**PREFERRED PROJECT REPORT  
MP 10\_0107**

**61 MOBBS LANE, EPPING – STAGE 1 TOWNHOUSE  
DEVELOPMENT**

**NOVEMBER 2010**

7 BLDG 1 (TYPE 3) FRONT ELEVATION
1:100

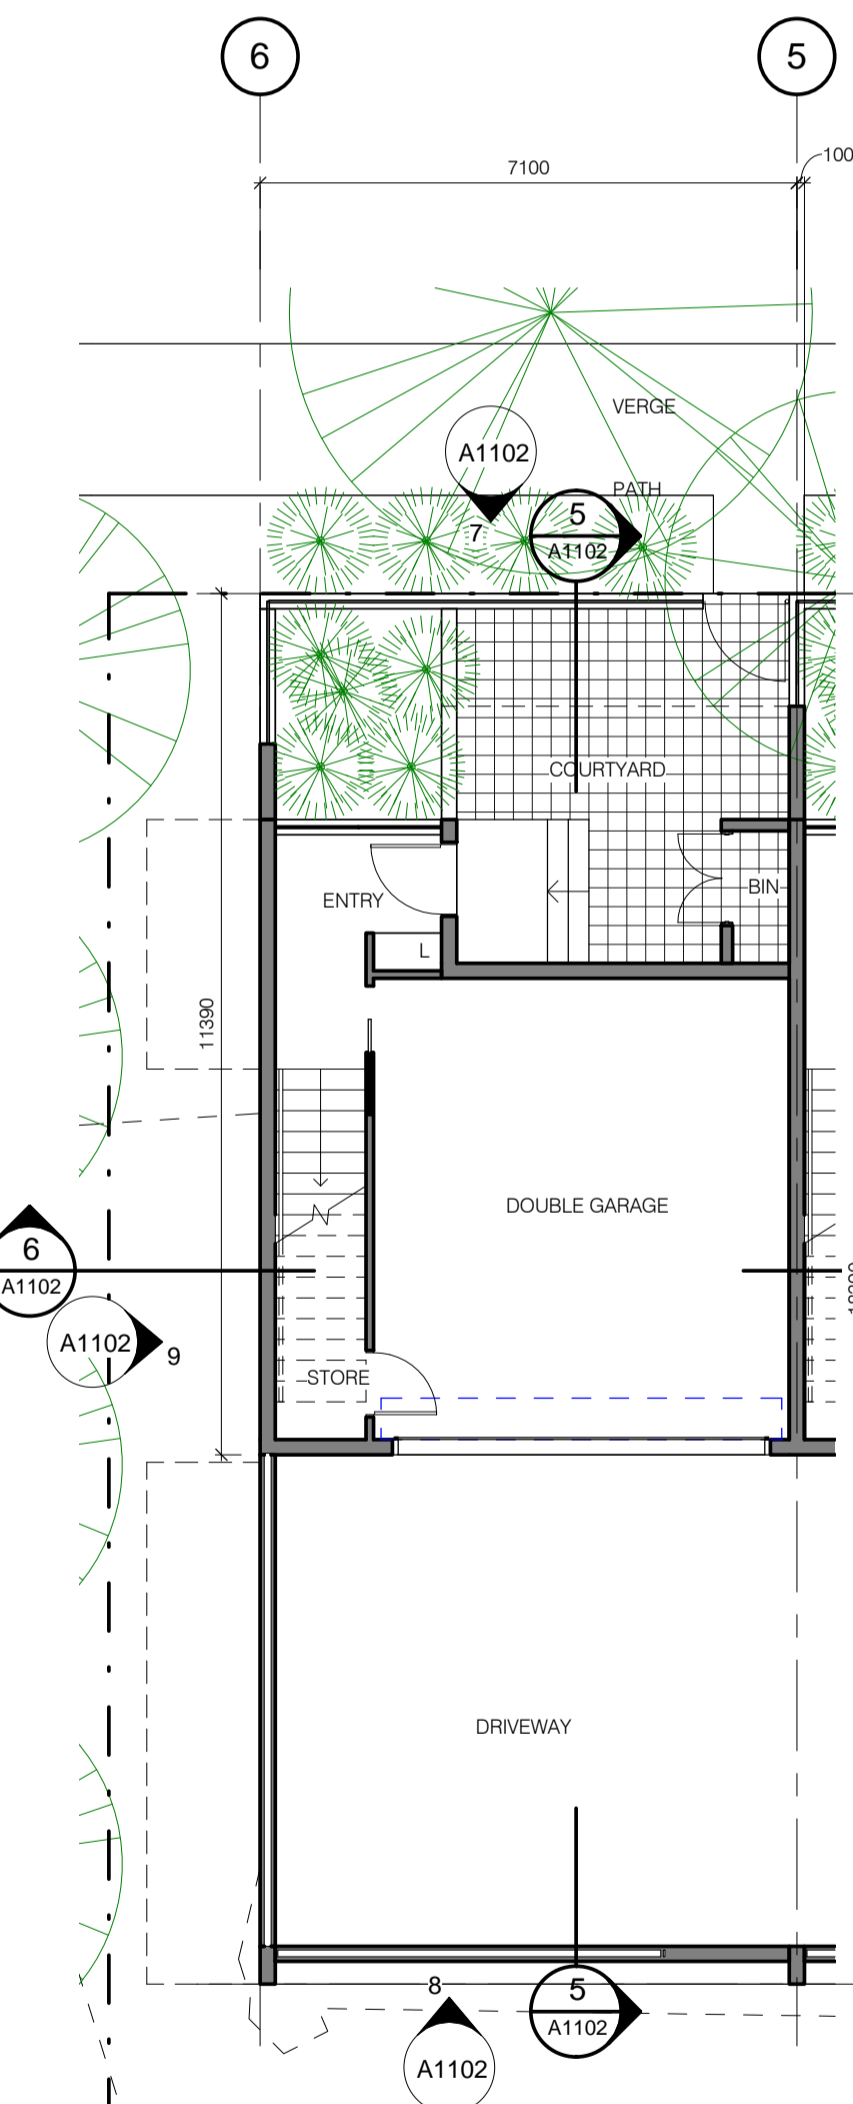
Issue: Increase passive surveillance from Buildings 1 & 2 towards Mobbs Lane.

Response: Buildings 1 and 2 have excellent surveillance towards Mobbs Lane as the buildings have a large balcony which directly over looks the street. In addition, the dining room and kitchen areas are orientated onto the balcony. These are rooms within a dwelling which are in constant use, thus providing constant surveillance. Refer to photomontage No. A1301 (attached in **Annexure 4**) which clearly demonstrates the relationship between the buildings and the street, and the position of the balcony.
